Our Ref: FP/46/20/HH
Your Ref:

Town & Country Planning Act 1990 (as amended)
Town & Country Planning (Development Management Procedure) (England) Order 2015
Application for Planning Permission for Works or Extension to a Dwelling

Development Front and rear dormers, ground floor side extension to replace existing garage and conservatory.
Location 48 Roundle Avenue Felpham

DRAWING BLOCK PLAN DATE: FEBRUARY 2020 DRAWN: T. Murray	SCALE 1/500
DRAWING: 20/08/3	REVISION:

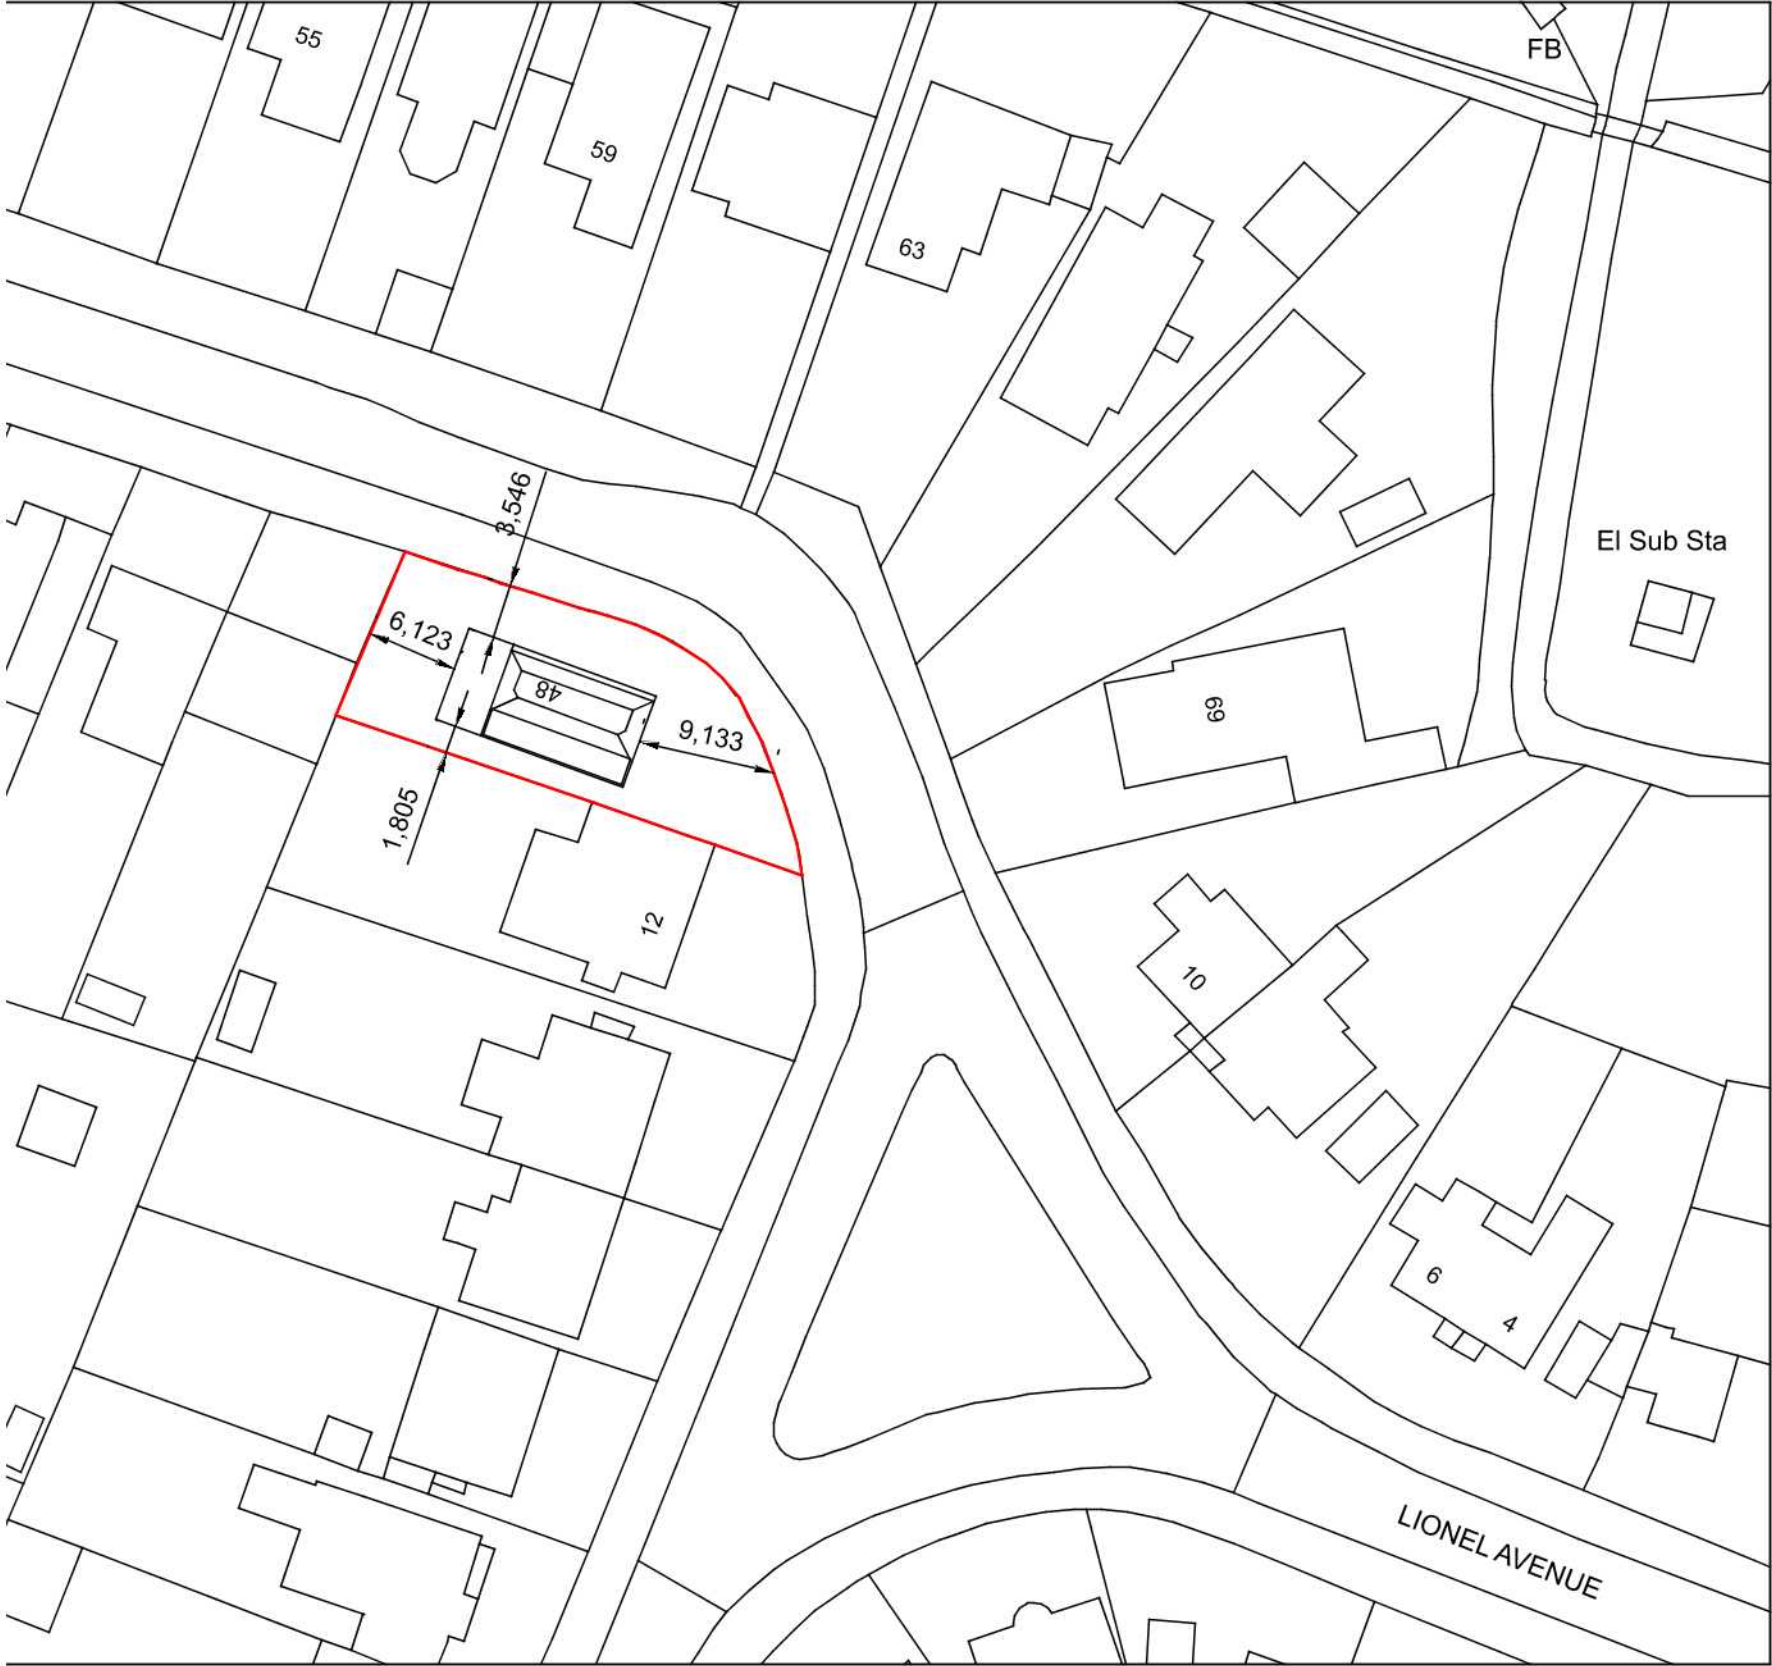
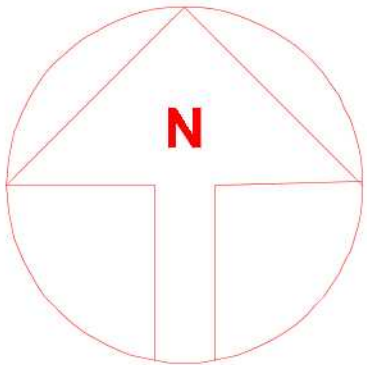
Block Plan: You are required to include dimensions on the block plan from the proposed extension to all site boundaries.
